*Third Party Submission to Referral –
ABP-302769-18
(PA Reg Ref: P/DC/3/14/18)*

"Whether the conversion of a ground floor office space for use as a two-bedroom apartment is or is not development or is or is not exempted development".

*Ti Choinn, Gleann na Ri, Murrough, Galway
City*

Gleann na Ri Management Company

File Ref: Subject: 3.09 Existing building - Plans, Elevations & Section
 Project No: 18161
 Drawing No: 3102
 Rev. 1
 O'Neill | O'Malley Ltd.
 Architecture + Project Management

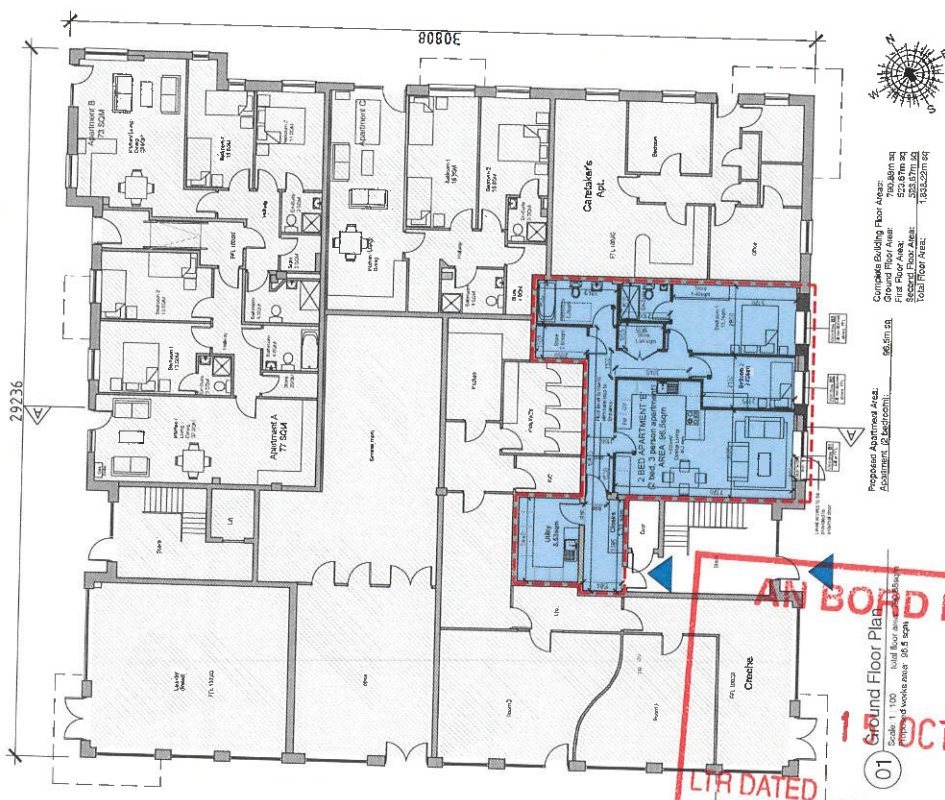
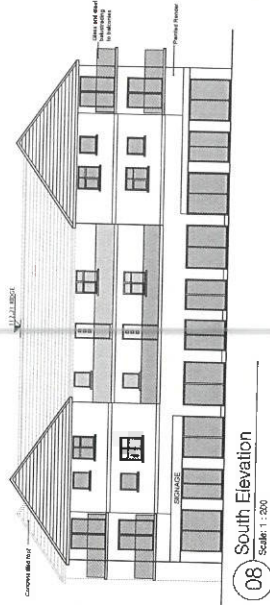
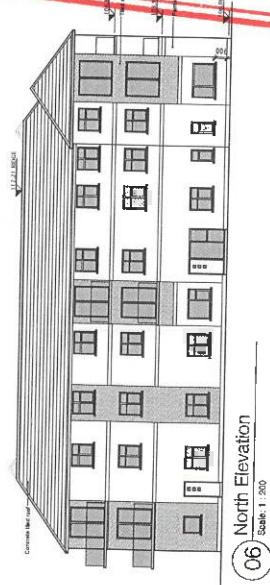
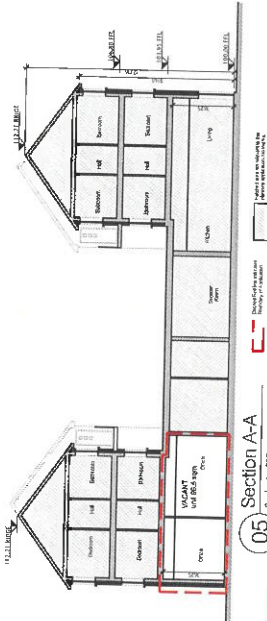
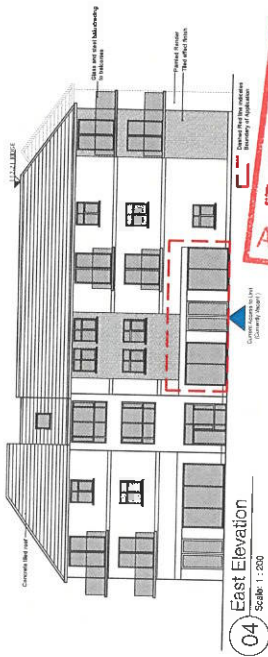
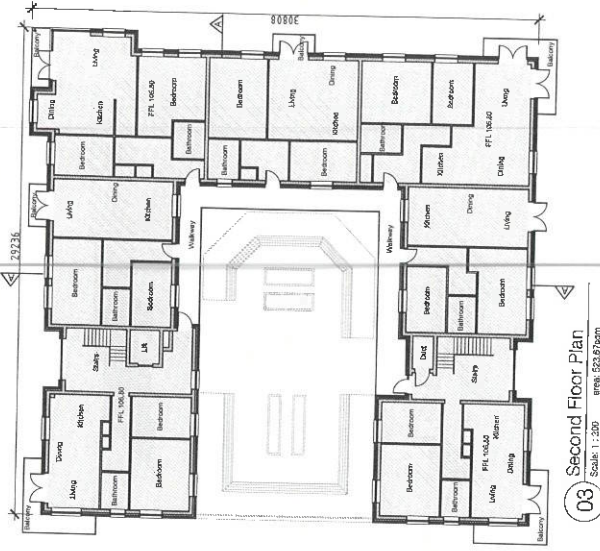
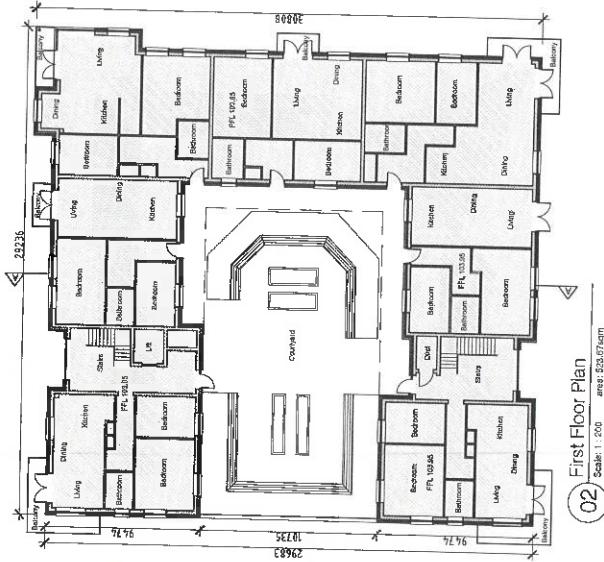
<p>6(d)(i) <i>"The development is commenced and completed during the relevant period."</i></p>	<p>This is subject to compliance with the other criteria.</p>
<p>6(d)(ii) <i>"Subject to sub-paragraph (iii), any related works, including works as may be required to comply with sub-paragraph (vii), shall affect only the interior of the structure and shall not materially affect the external appearance of the structure so as to render its appearance inconsistent with the character of the structure or of neighbouring structures."</i></p>	<p>It should be noted that the applicant has now proceeded with the "proposed works" and the external changes are now complete (See Figure 1 above). The south east elevation is the main elevation facing onto the access road/public realm. In time this thoroughfare could potentially serve the extensive Murrough Local Area Plan area (LAP), further to the south. The reduction in the glazing along the subject unit is significant, and is inconsistent with the frontage of the adjoining creche, and will materially affect the external appearance of the structure.</p>

<p>6(d)(iii) <i>"Any related works for the alteration of existing ground floor shop fronts shall be consistent with the fenestration details and architectural and streetscape character of the remainder of the structure or of neighbouring structures."</i></p>	<p>Again the alteration of the existing "shopfront" is considered to be inconsistent with the character of the remainder of the structure (especially the creche unit).</p>

I wish to make you aware that the proposed drawings ignore the existence of the Gleann Na Ri communications room that contains the essential common area services of the estate. The Gleann Na Ri estate comprises of fourteen apartment complexes and the entire estate's CCTV cables, CCTV equipment, telephone and internet lines and patch panels, fibre optic cables, gate communication cables and all of the fire alarms cabling and connections are housed within this area. I have outlined the location of these services on the attached drawing. It is not possible for the management company to operate without having access to these essential services located in this area.
